Appeal Decision

Appeal Ref: APP/R5510/D/23/3318278

64 Hartland Drive, Ruislip, Hillingdon HA4 0TH

- The appeal is made under section 78 of the Town and Country Planning Act 1990 against a refusal to grant planning permission.
- The appeal is made by Dr Senthuran Jeyapalan against the decision of the Council of the London Borough of Hillingdon.
- The application Ref 40278/APP/2022/2898 dated 19 September 2022, was refused by notice dated 16 December 2022.
- The development proposed is erection of a brick conservatory to rear and demolition of existing garage at rear of garden.

PROPOSED GROUND FLOOR PLAN (Scale 1: 50)

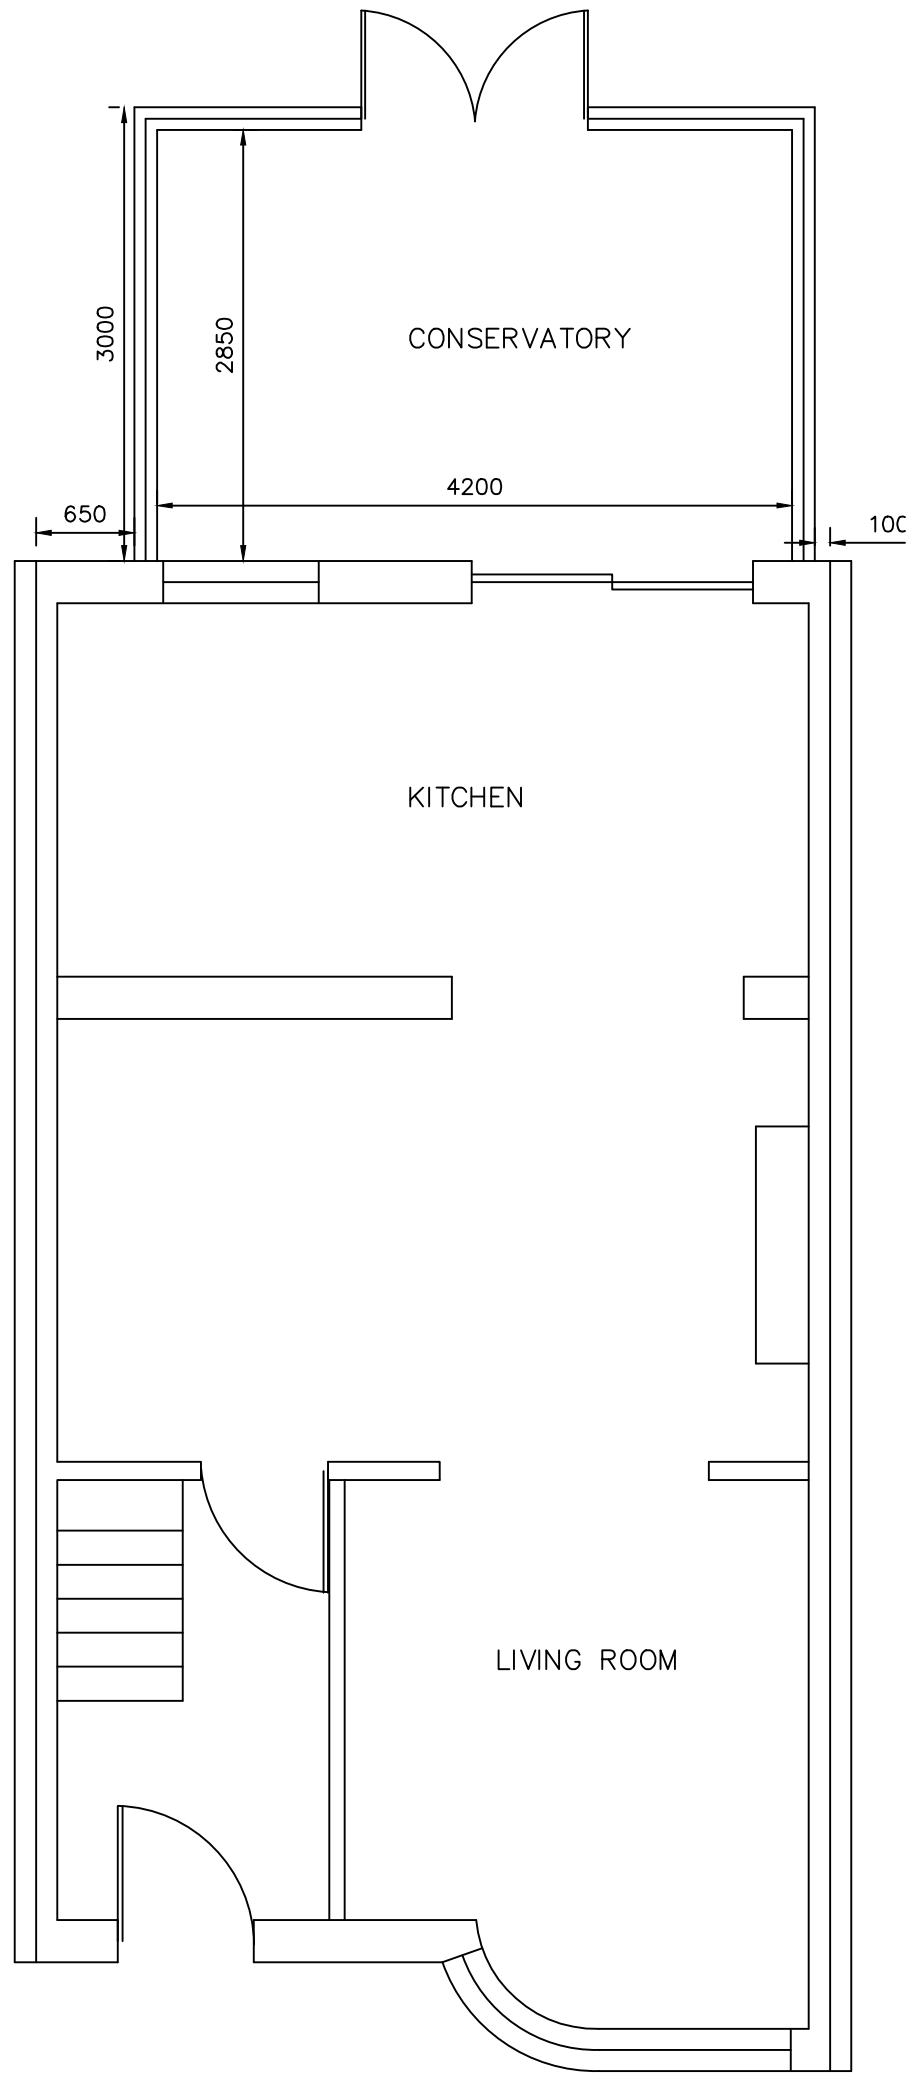
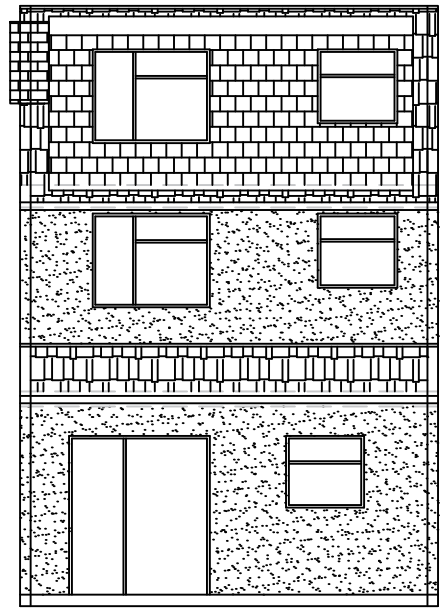
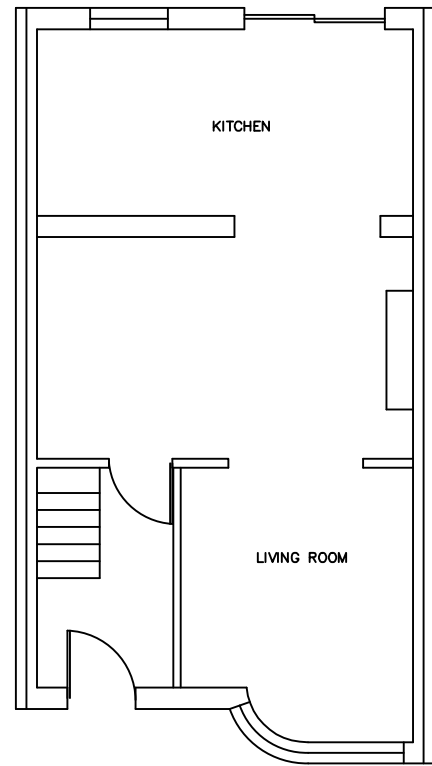
8. The proposed development would project 3m beyond the existing rear extension. The existing single storey rear extension is similar in scale and design to those at No's 62 and 66. High boundary fencing surrounds the appeal plot limiting views to a degree into adjacent gardens.

9. No. 66 Hartland Drive has a conservatory projecting from the rear extension which is set off the shared boundary with the appeal site. The conservatory at No. 66 has clear glazing facing towards the appeal site. Notwithstanding this a condition could be imposed requiring the proposed development to provide obscure glazing along the side elevations to prevent overlooking.

10. Obscure glazing along the side elevations of the proposed development combined with the existing fencing would sufficiently mitigate any sense of being overlooked.

PROPOSED REAR ELEVATION (Scale 1:100)

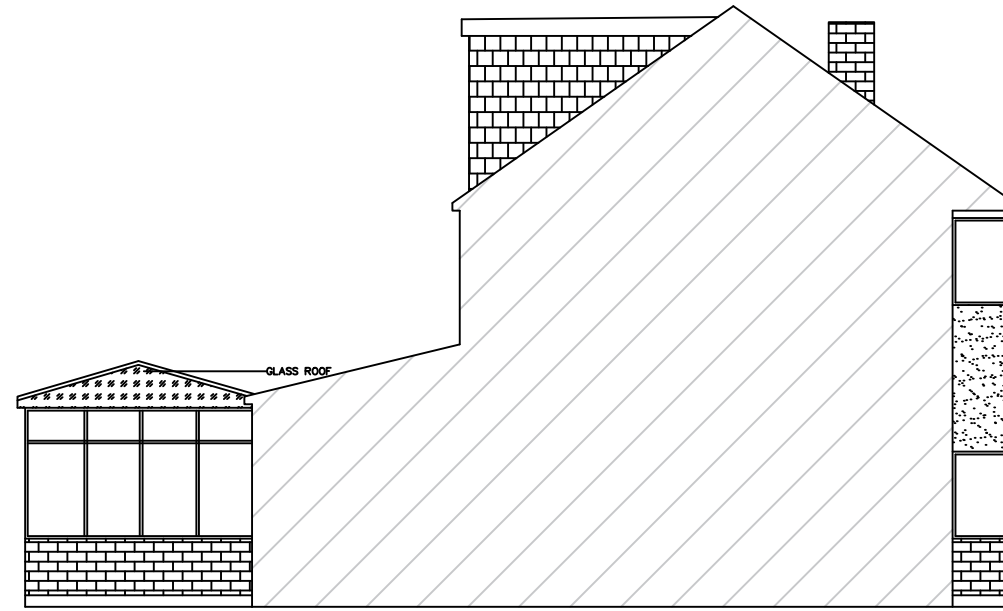
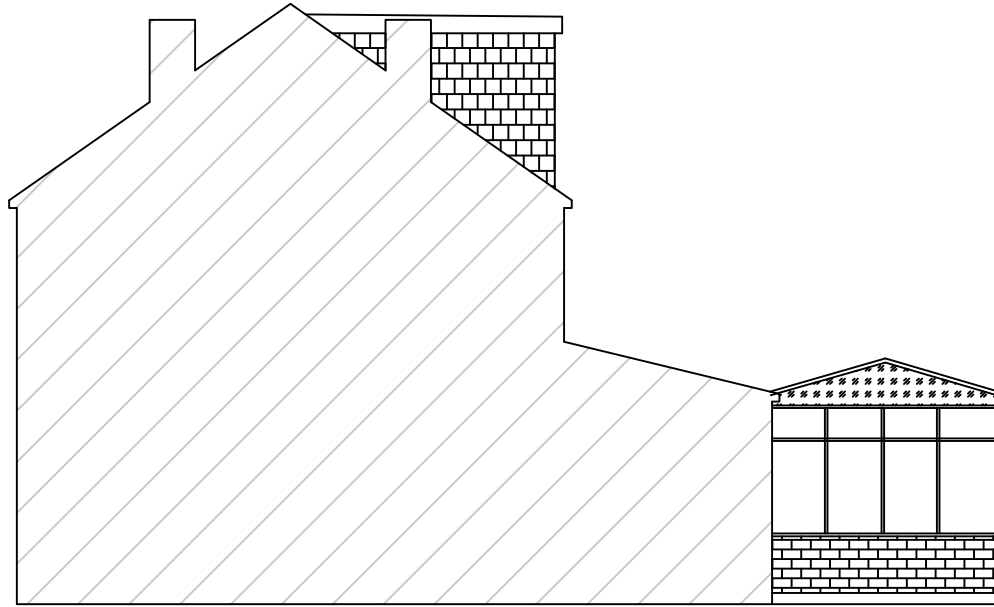
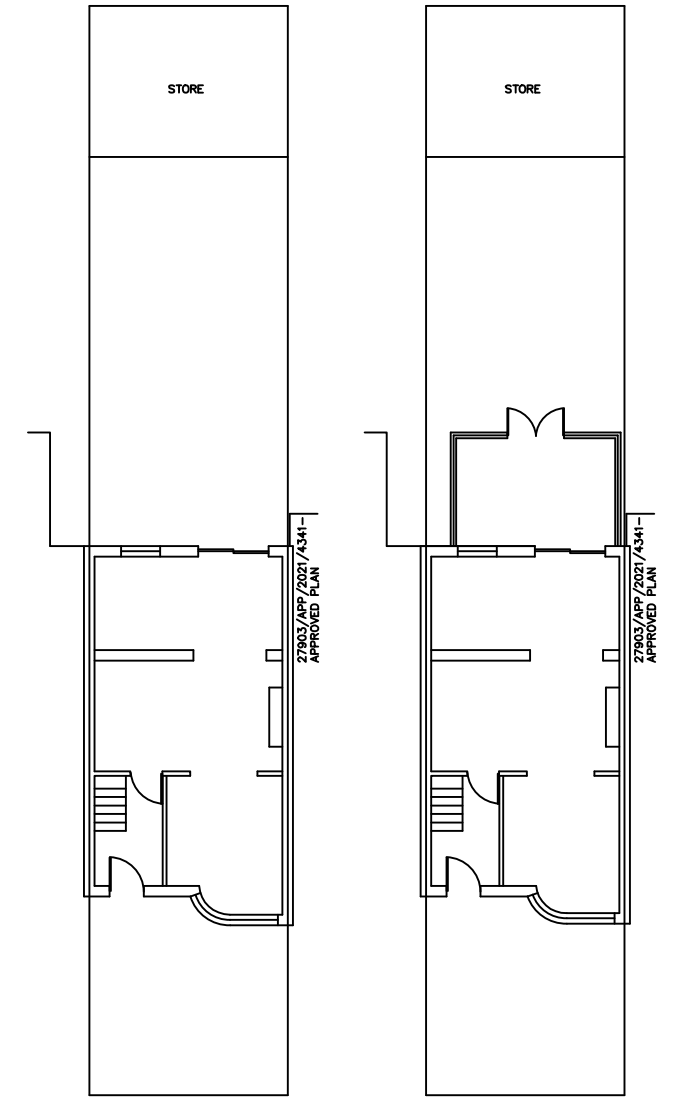
6. Notwithstanding this the roof design of the proposed development joining the shallow mono pitch roof of the existing extension would appear contrived and would be an unsympathetic and incongruous addition to the existing property.
7. I conclude that the proposed development would harm the character and appearance of the existing property and area in general. There is conflict with Policy BE1 of the Hillingdon's A Vision for 2026, Local Plan: Part 1, Strategic Policies (2012) (the Local Plan: Part 1) and Policies DMHB 11 and DMHD 1 the Local Plan: Part 2 which amongst other things seek to ensure developments are of high quality design which respect the design of the original property.
